DRB CASE ACTION LOG (Preliminary/Final Plat)

DRB Application No.: 10DRB- 70015 Project # 1008059
Project Name: North Albuquerque Acres Unit B
Agent: Slagle Herr Architects Phone No.: _____

SUBJECT: Project # 1008059

On December 18, 2009, the Environmental Planning Commission approved Project # 1008059 09EPC-40061, a Site Development Plan for Building Permit, for all or a portion of Lots 4-6, Block 4, Tract A, Unit B, North Albuquerque Acres, located on Venice Avenue NE between San Mateo Blvd NE and I-25 containing approximately 2.66 acres.

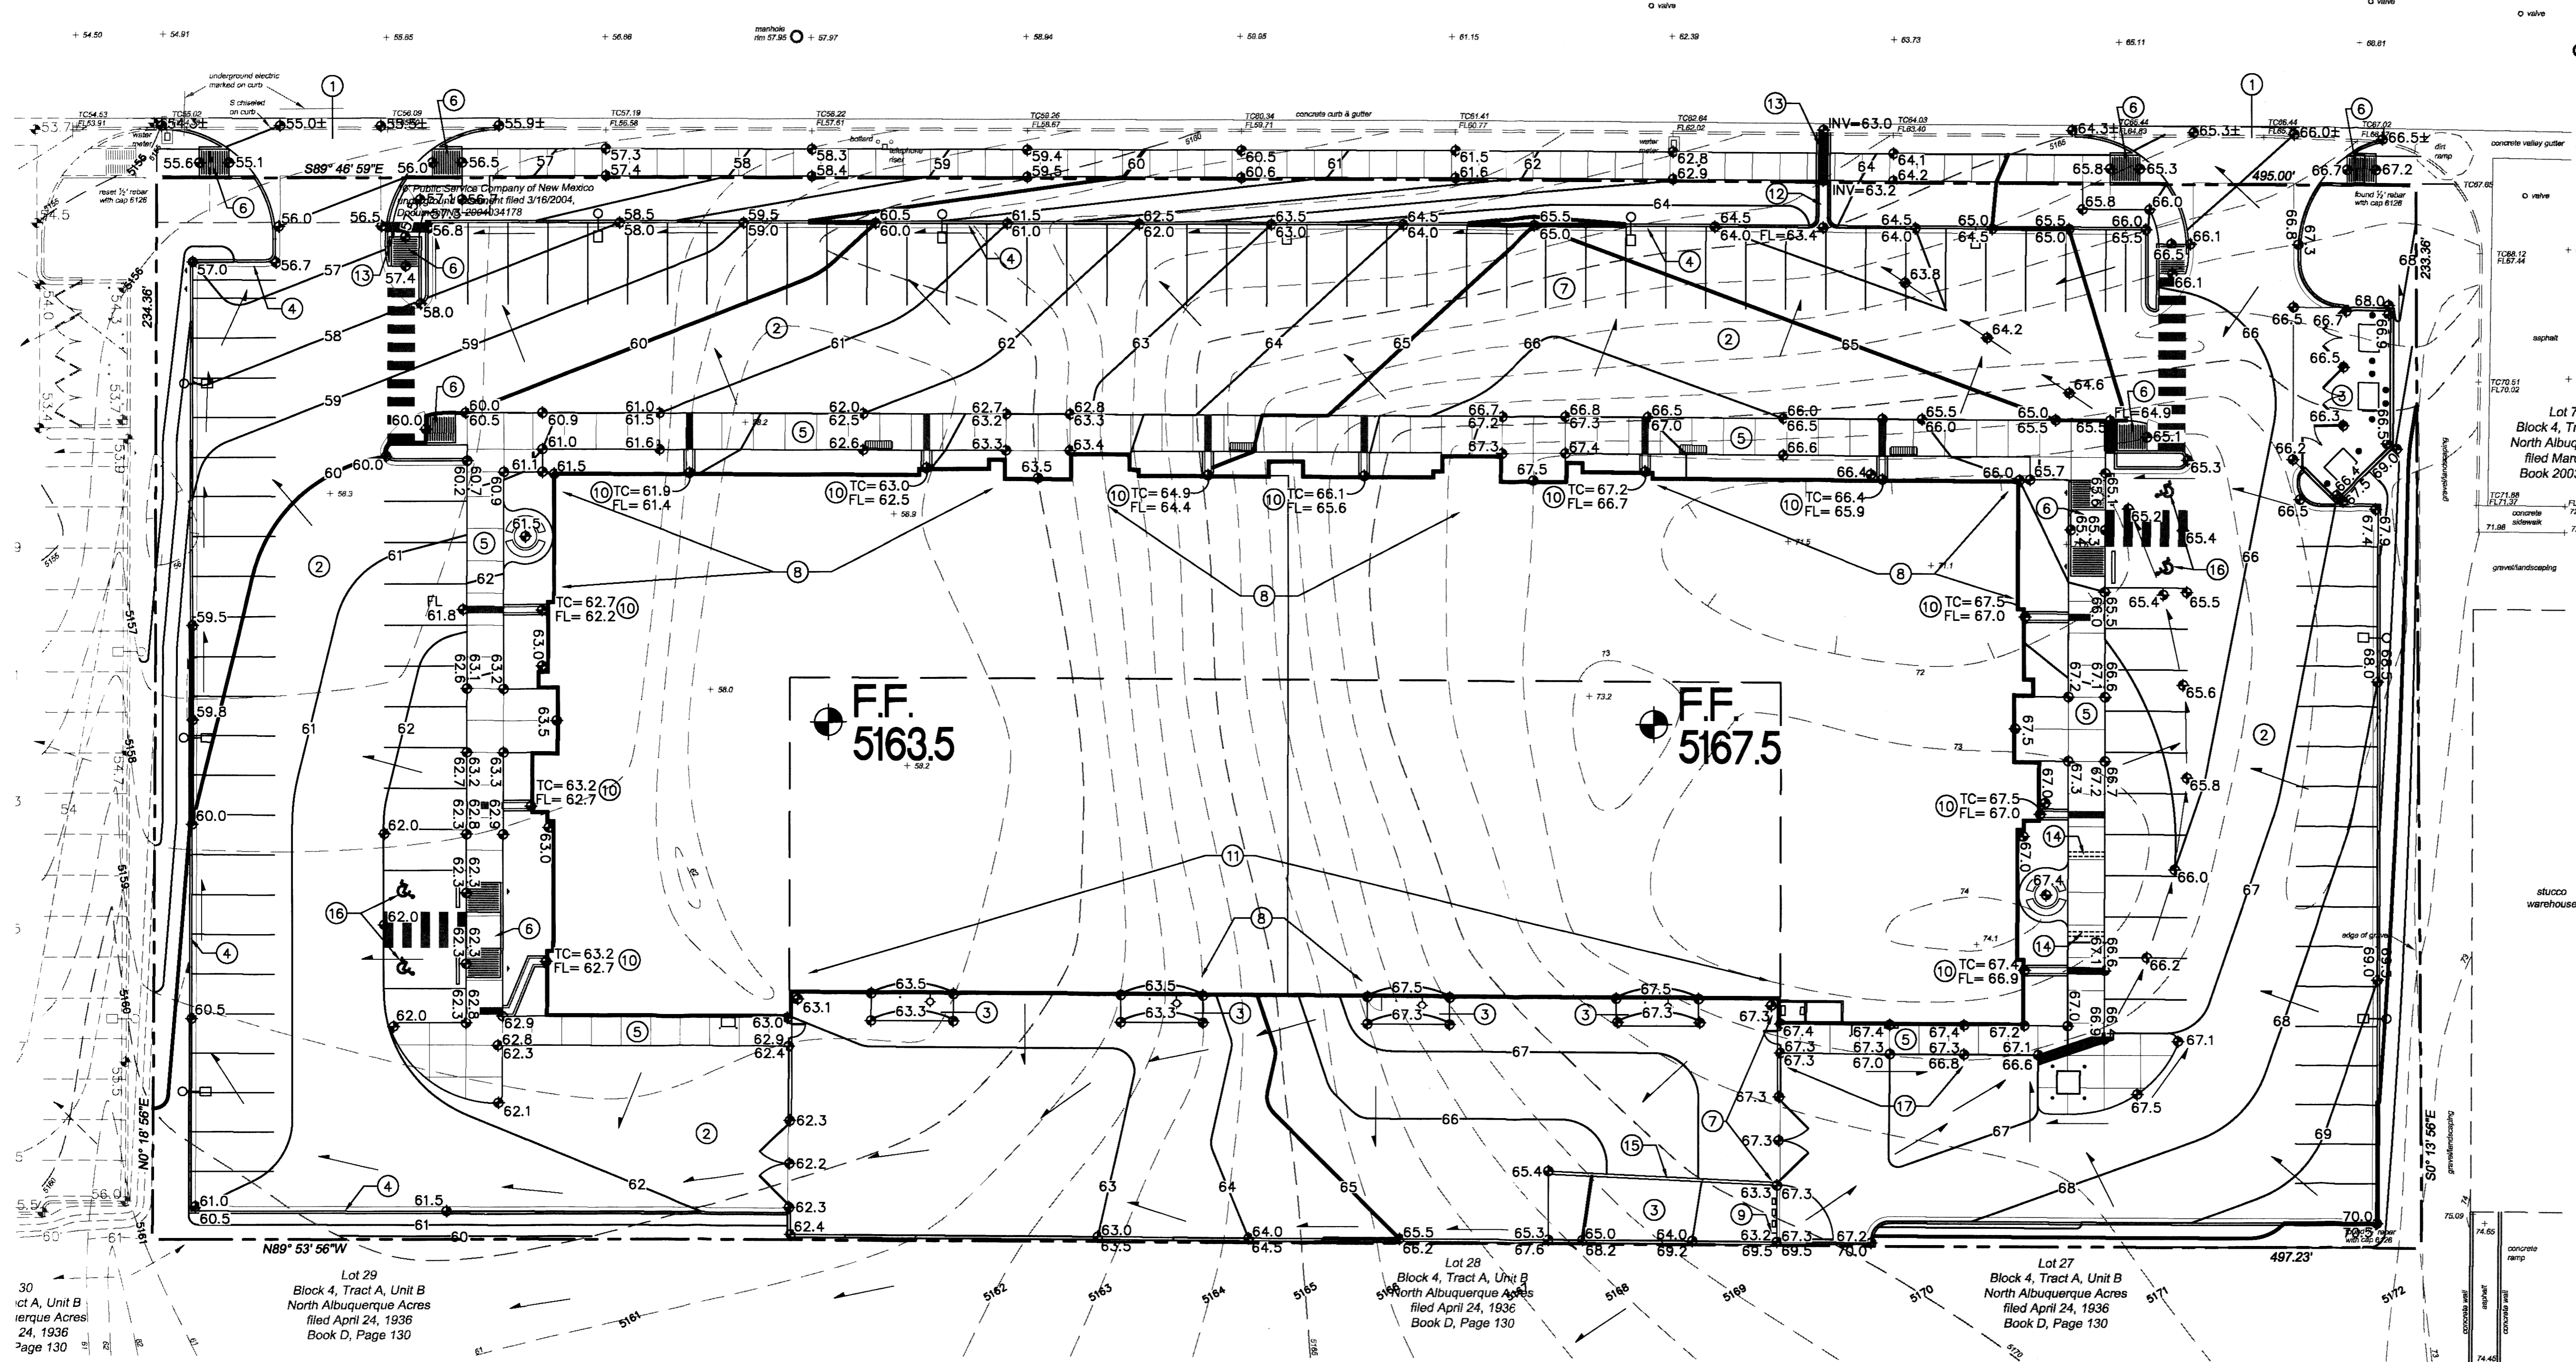
6. Landscaping:
 - a. The Landscaping Plan (Sheet L2 of L2) shall show 16 street trees required and 15 street trees provided. One additional street tree (can be an accent tree) shall be added to the landscape plan along Venice Avenue.

Condition 6a: The Landscape Plan has been updated to show 16 street trees required and 15 street trees provided. One additional tree has been added along Venice Avenue.

ELECTRICAL SITE PLAN

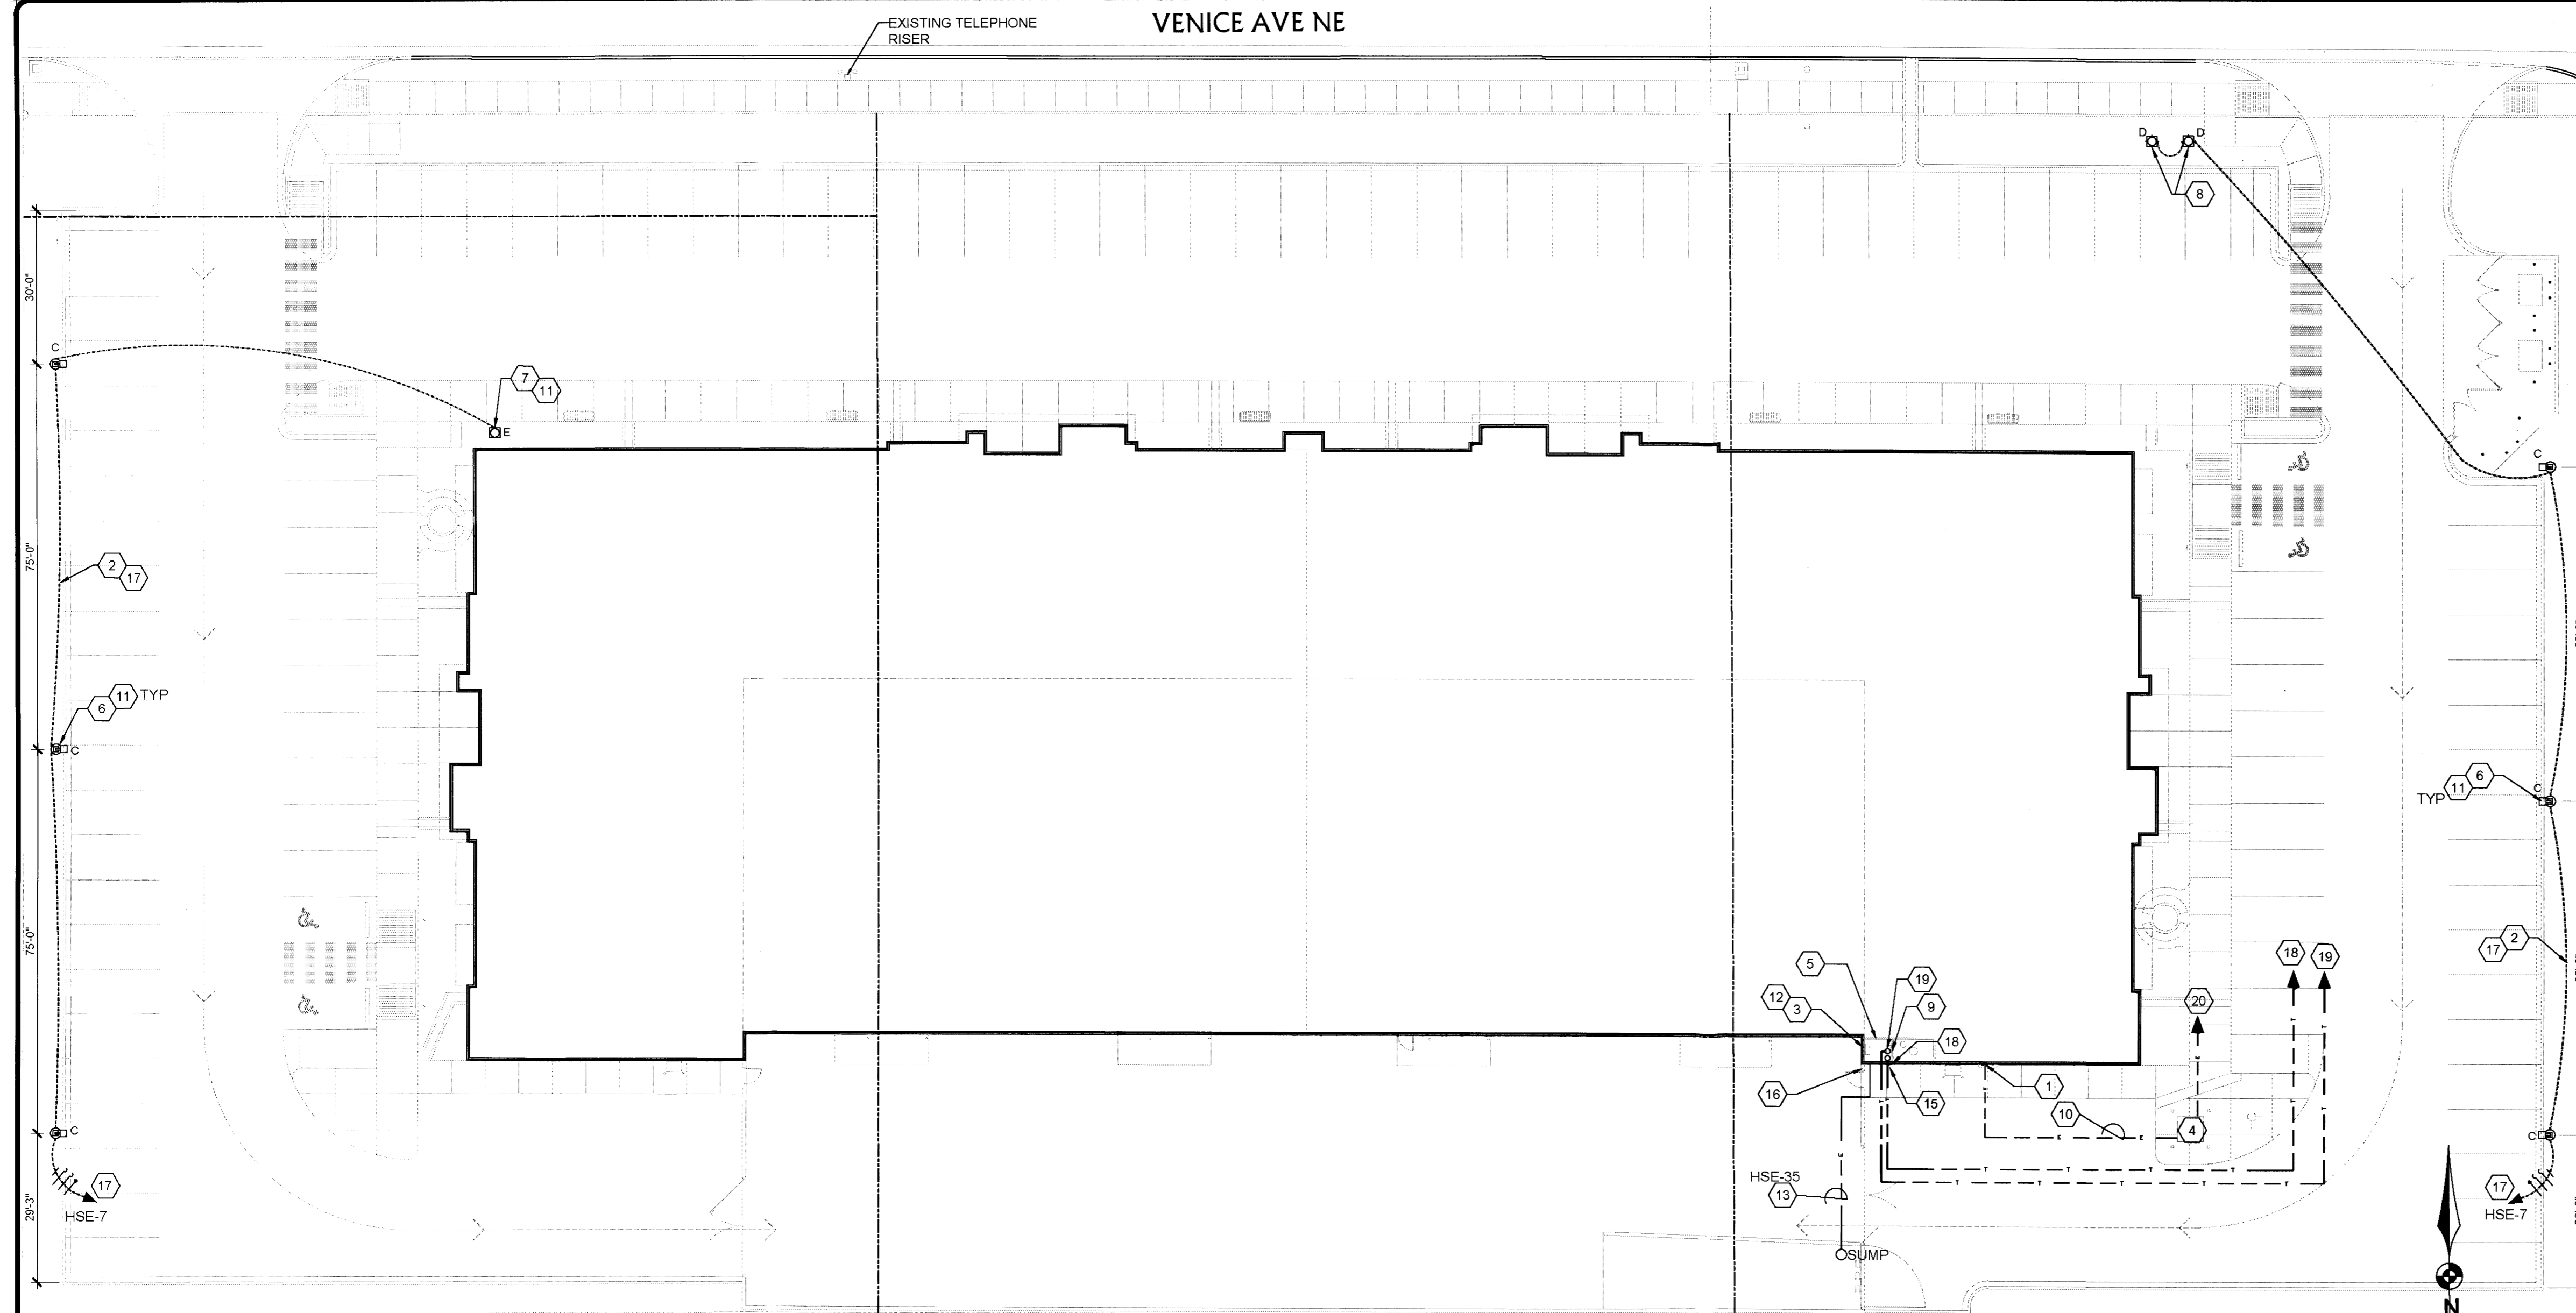
Condition 5: The applicant shall cluster trees together to minimize conflicts between lighting and trees around the perimeter of the site, while still meeting all the requirements of the Zoning Code and the Street Tree Ordinance.

The 2nd most easterly light pole along Venice Avenue needs to be moved approximately 10 feet to the east so that it is in between the Autumn Purple Ash and the Honey Locust trees.
